Application No: AB/75/20/PL

Recommendation Report for Planning Permission

LOCATION: 55-57 High Street
Arundel
BN18 9AJ

PROPOSAL: Conversion of existing mixed use space to 1 No. 1- bedroom flat. This application affects the character & appearance of the Arundel Conservation Area & affects the setting of a Listed Building.

## Proposed Ground Floor Plan

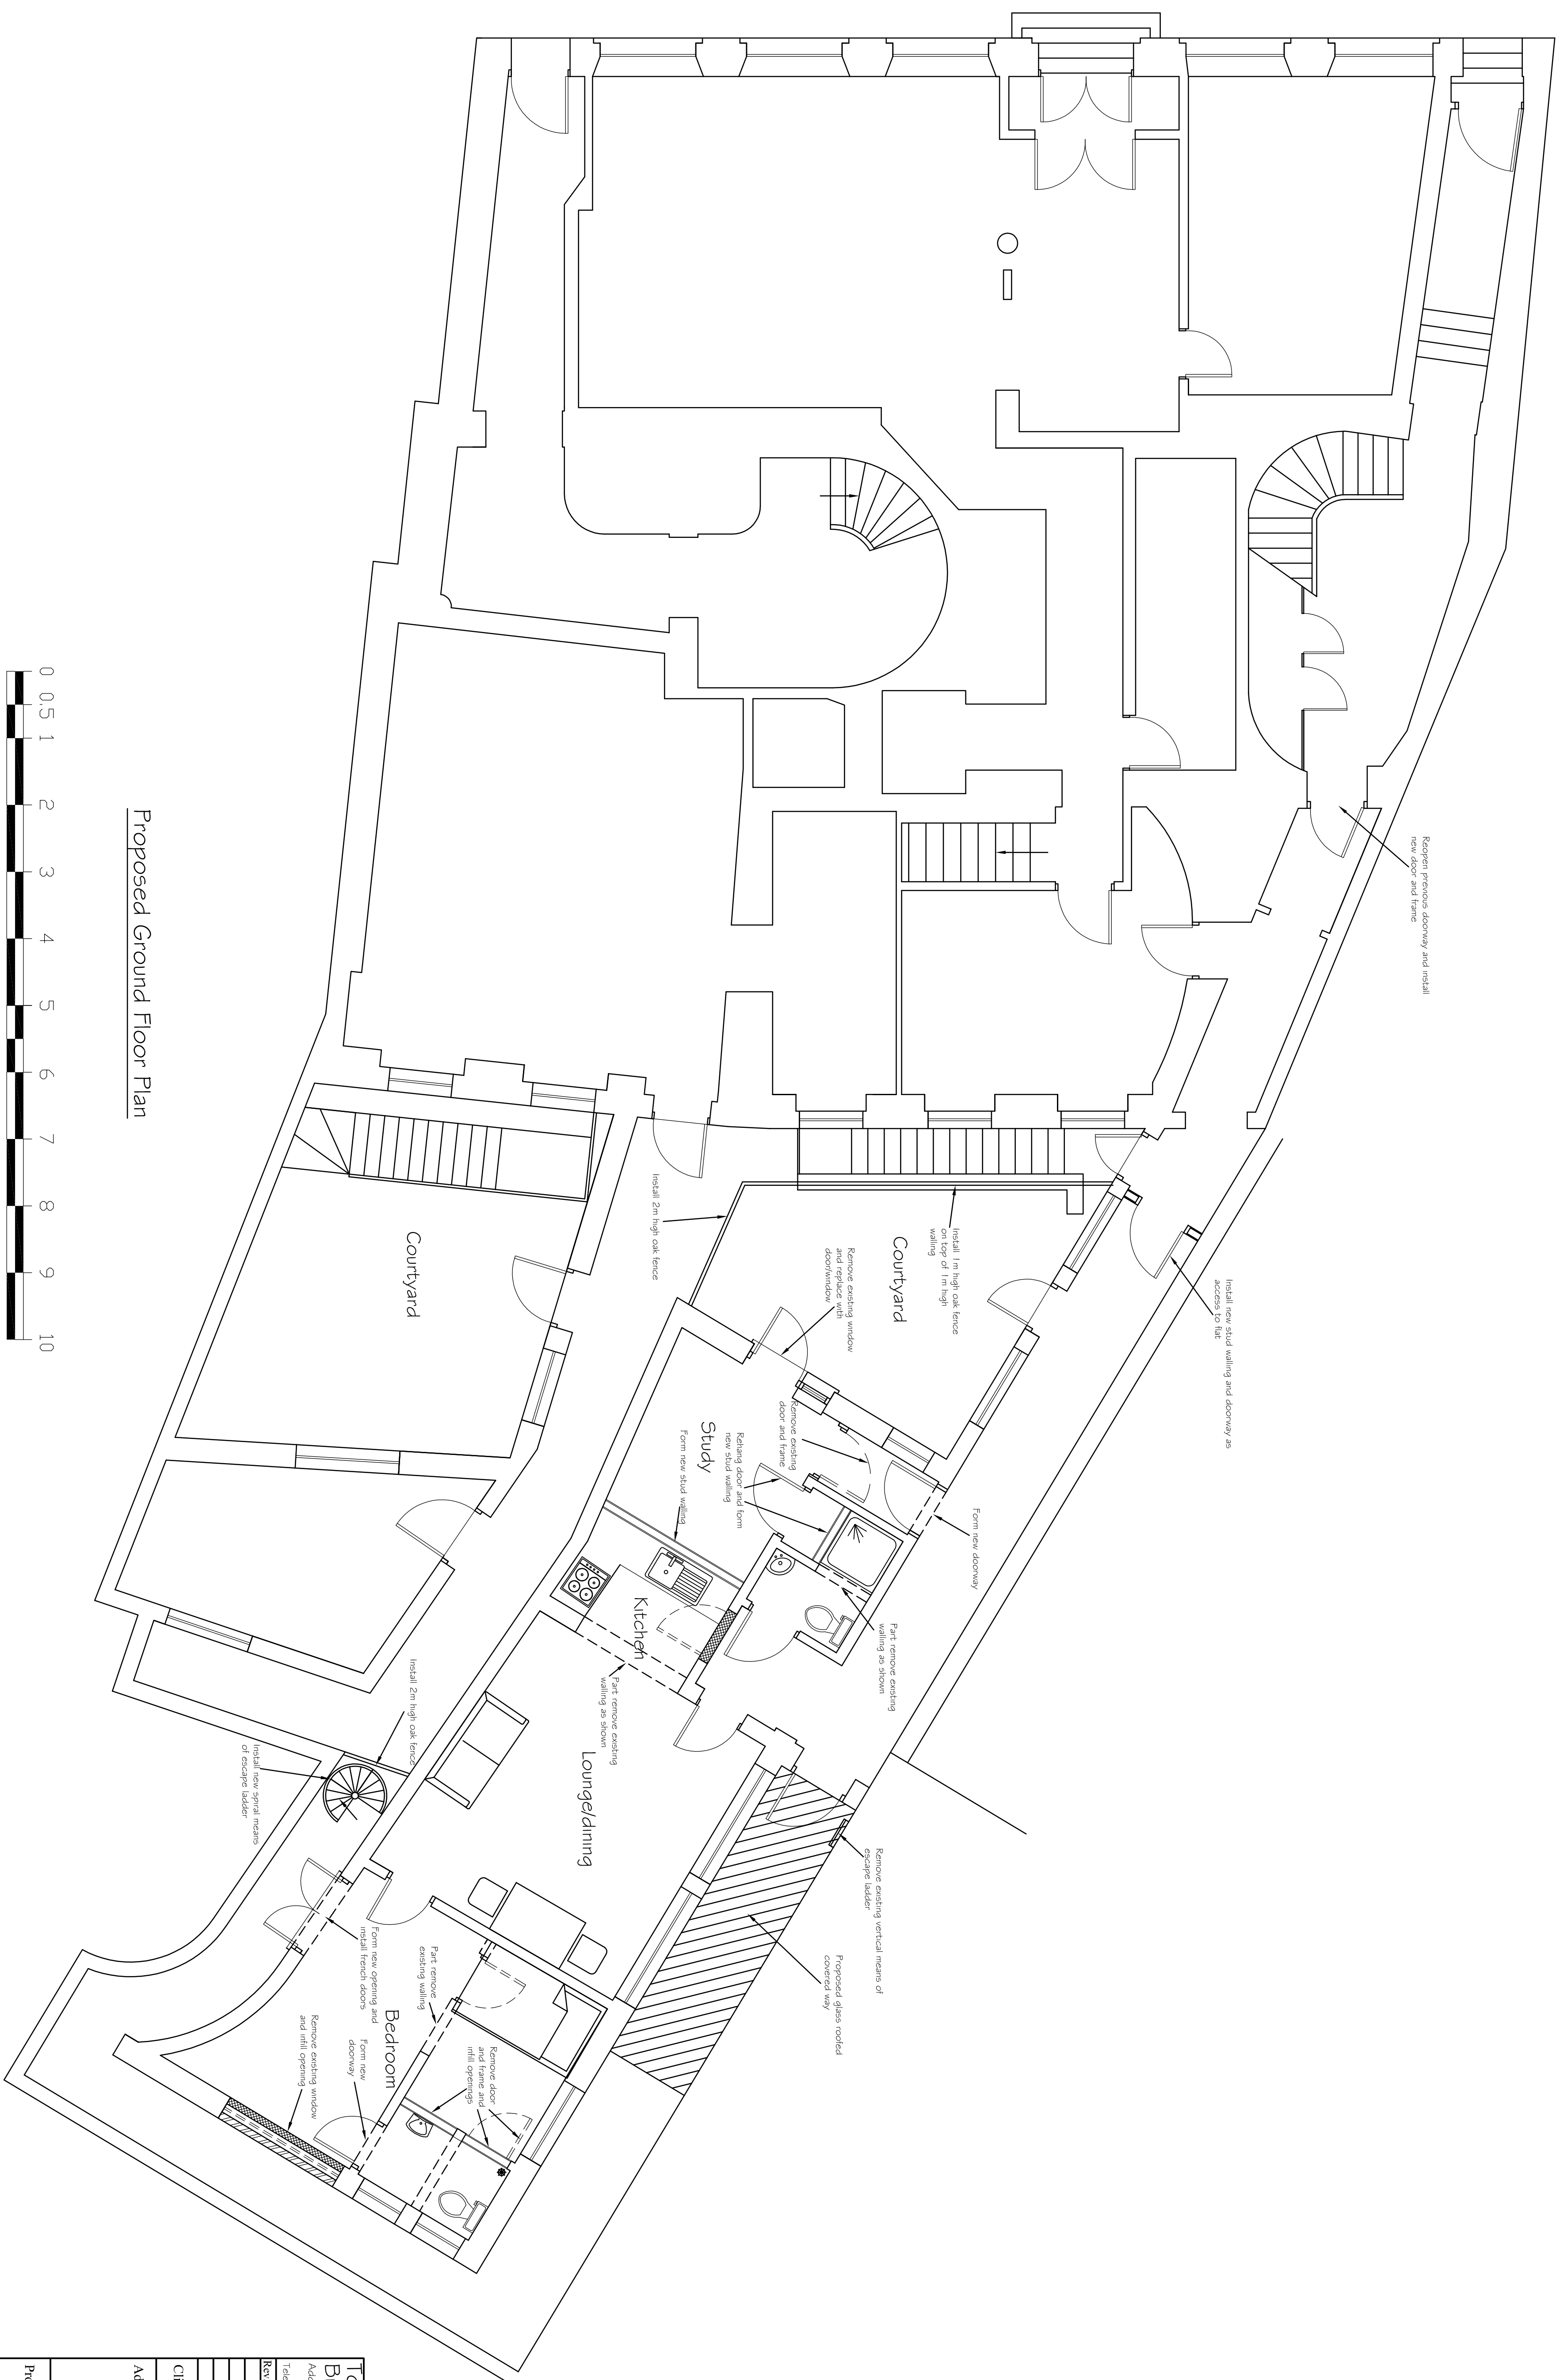
The external changes included within this application relate to the installation of french doors to the bedroom together with the infilling of one bedroom window. One of the windows to the study will be replaced with a door/window under the same opening. The existing vertical means of escape ladder will be replaced with a spiral staircase adjacent to the bedroom. New fencing will be installed to separate the dwelling from the other ground floor flat. The new doors and door/window will be in timber and all the existing Crittall windows will be retained. Precise details of the materials to be used for the conversion will be controlled by condition when the listed building consent application is considered.

A new boundary treatment comprising oak fencing is to be installed to provide private external amenity space to the unit. This courtyard area measures 4.5m wide by 2.2m at its minimum depth.

The floor area of the study room is small (2.7m by 2.5m) and cannot be considered as a second bedroom. In order to provide one bedspace, a single bedroom should have a floor area of at least 7.5m² and is at least 2.15m wide.

A single storey 1 bedroom unit requires 50 sqm floor area for 2 person occupation. The internal floor area is 53 sqm. The proposal therefore provides satisfactory living environment for permanent occupation.
